Re: Exhibition of Modification Request for the Moorebank Precinct East Concept Plan (MP 10_0193 MOD 3) and Moorebank Precinct East Stage 2 (SSD 7628 MOD 2)

Moorebank Precinct East Concept Plan (MP 10_0193 MOD 3)

Moorebank Precinct East (MPE): Stage 2 MOD 2

**OSD BASIN STORAGE DETAILS**

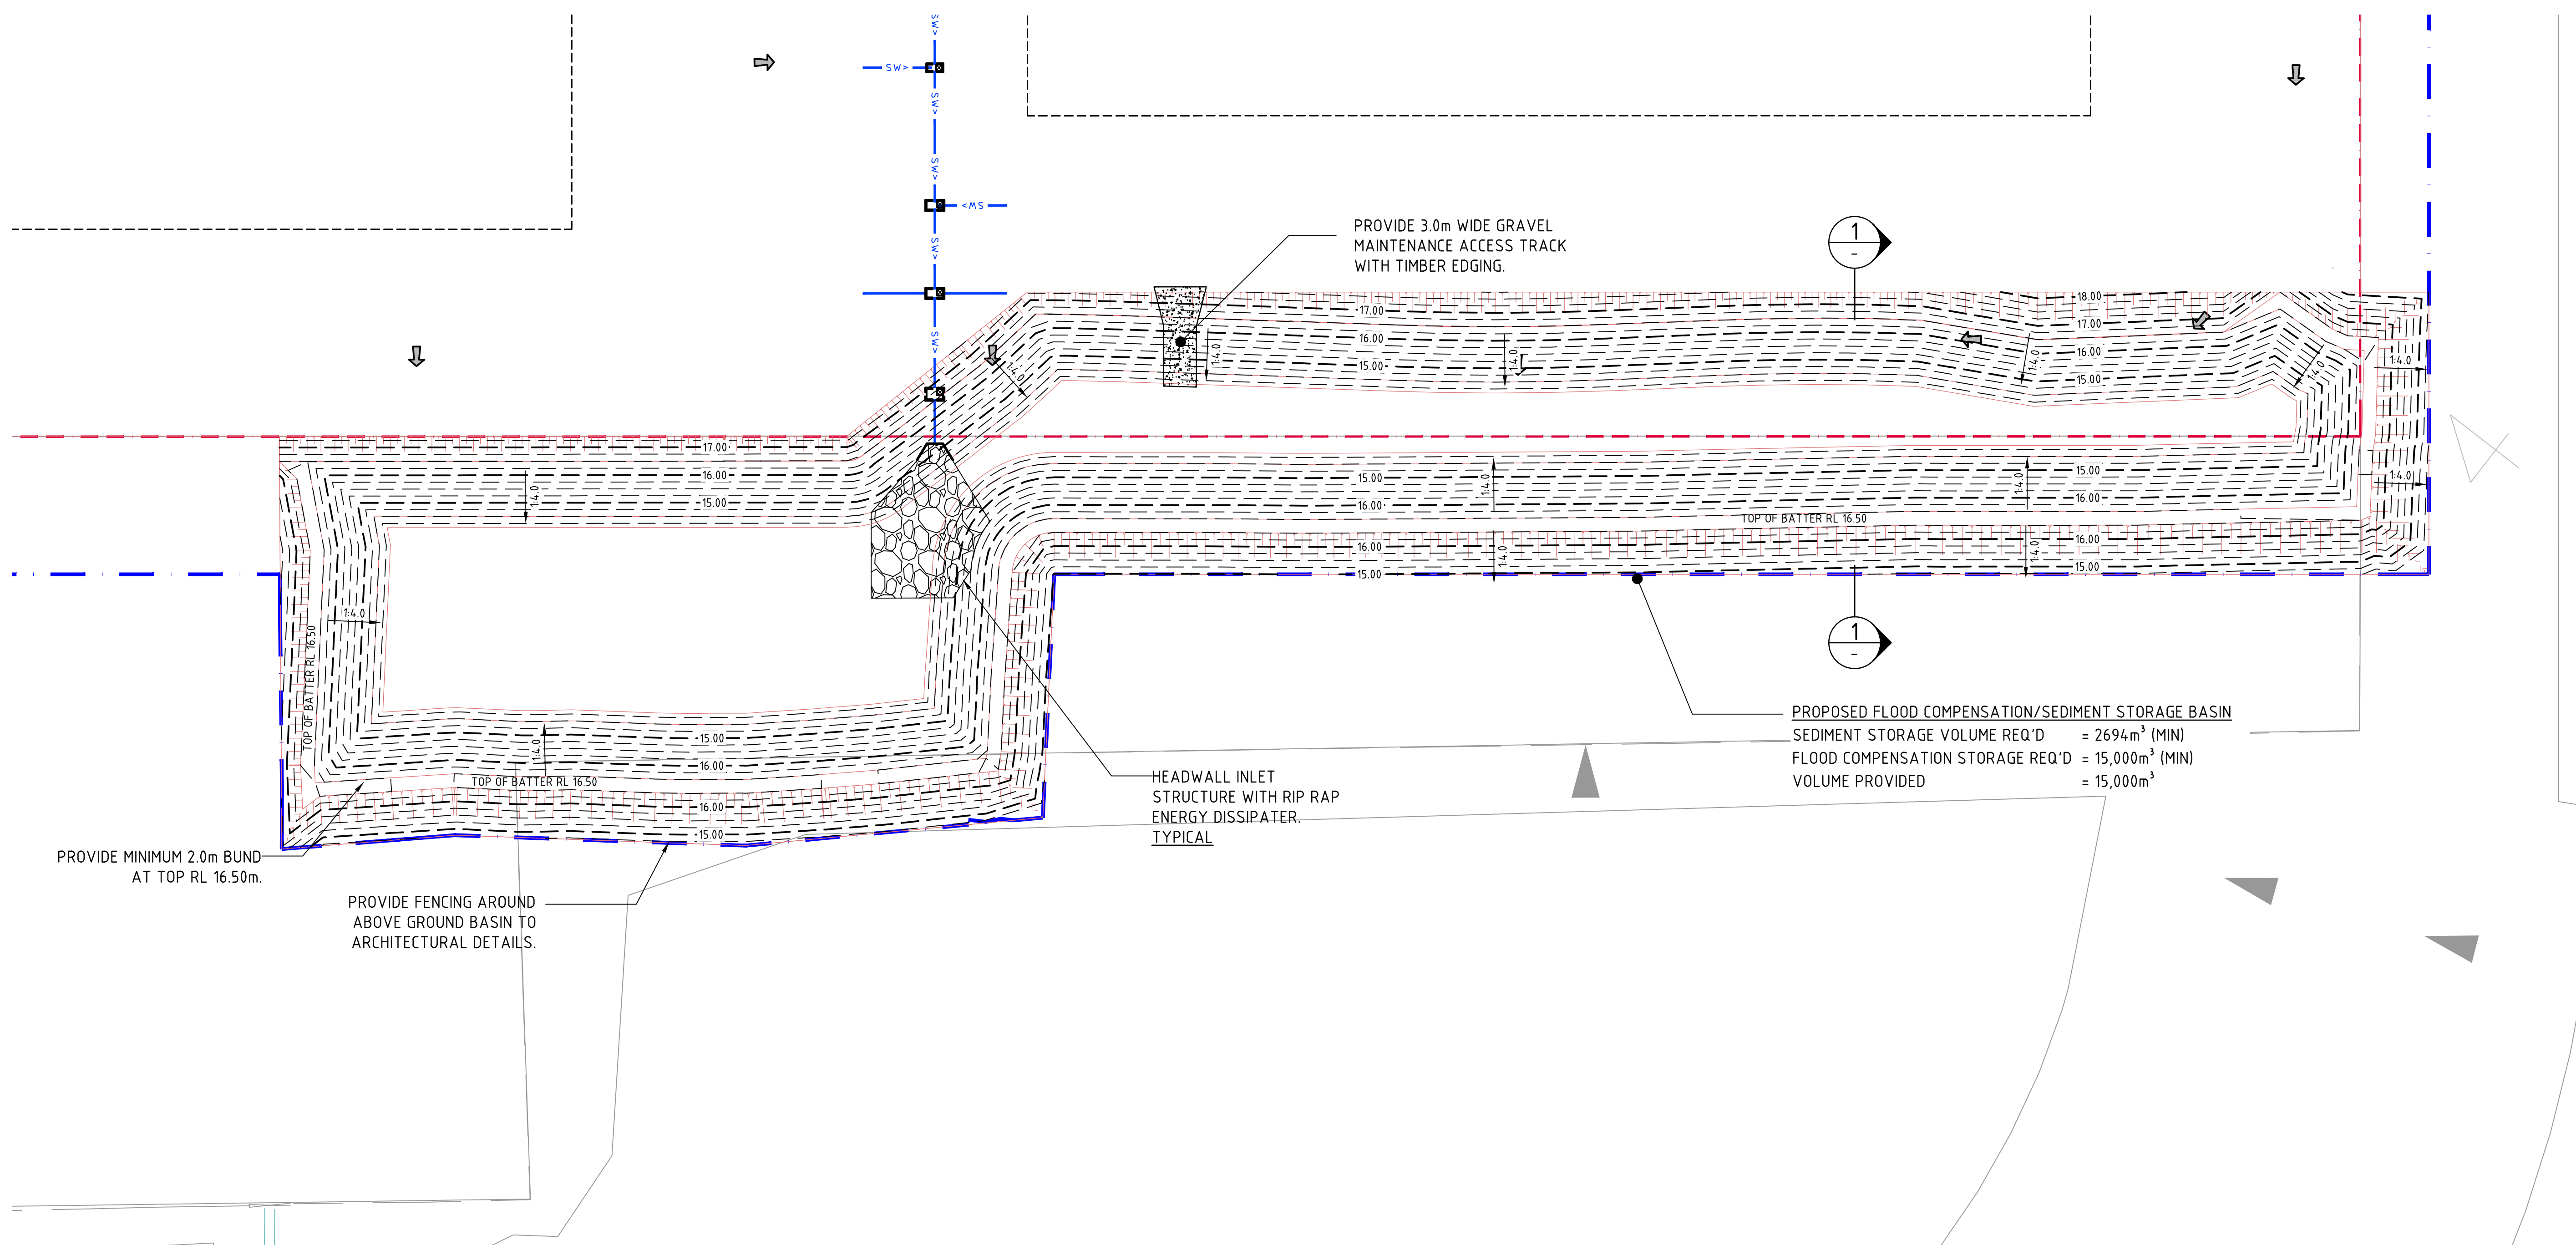
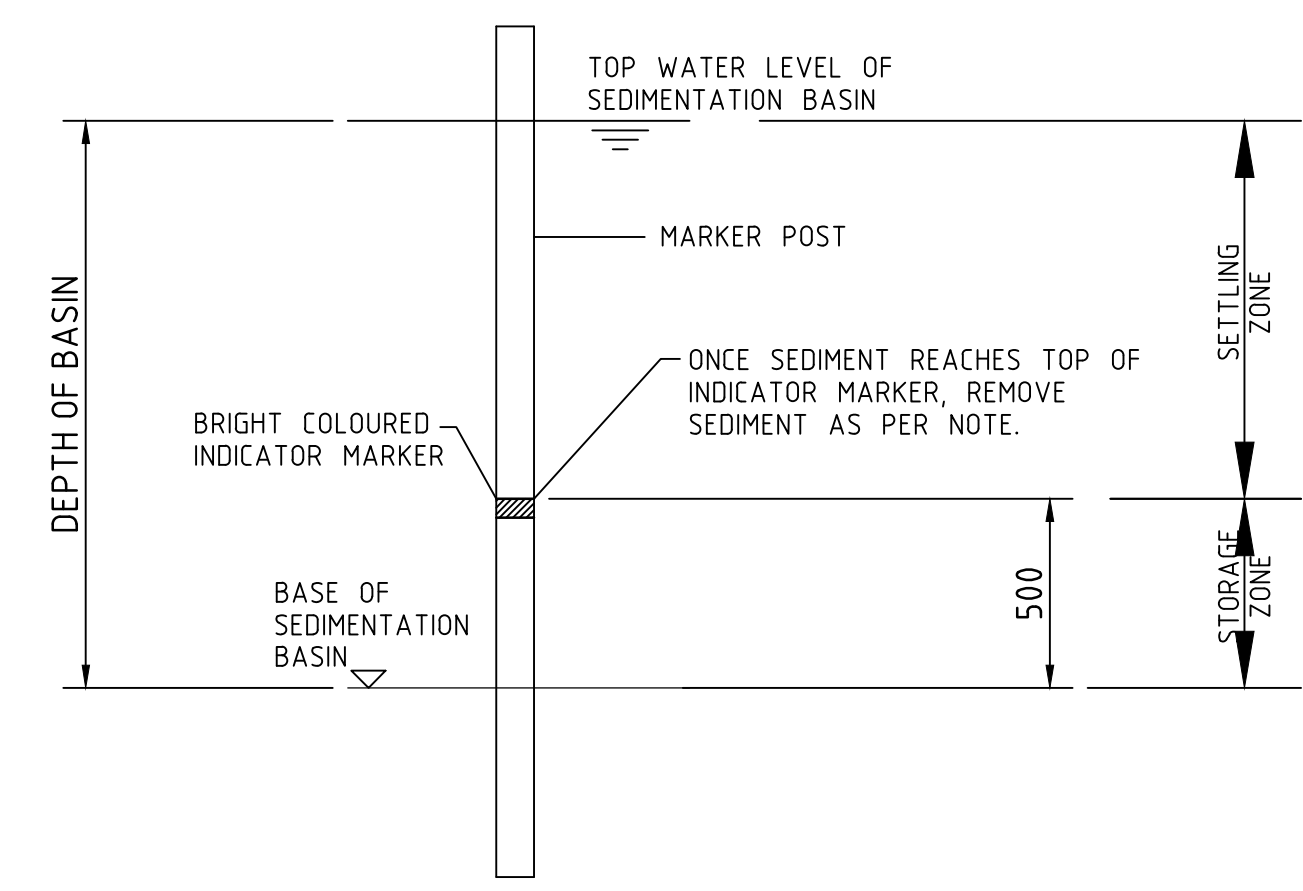
The proposed modification to stormwater detention basin 9 has been justified in a manner of ways. This includes providing safety precautions such as fencing, signage, access ramps, flood indicators, ladders and refuge areas. Council is satisfied with the proposed change to OSD 9 on the proviso that these safety measures are employed and maintained. In terms of visual impact, Council acknowledges that dark coloured mesh fencing with landscaping is proposed to soften the visage of the OSD. Council stresses the need to have high quality landscaping that provides a variety of amenity benefits along the boundary of the OSD. This landscaping should be selected carefully to ensure it is well suited to the climate of the locality, and is maintained to assure its ongoing health and function. Finally, it is Council's concern that if the water within OSD 9 is still for extended periods of time, stagnation may occur and attract mosquitos that could spread vector-borne diseases. This potential health issue should be addressed by the applicant, and effective mitigation strategies implemented accordingly.
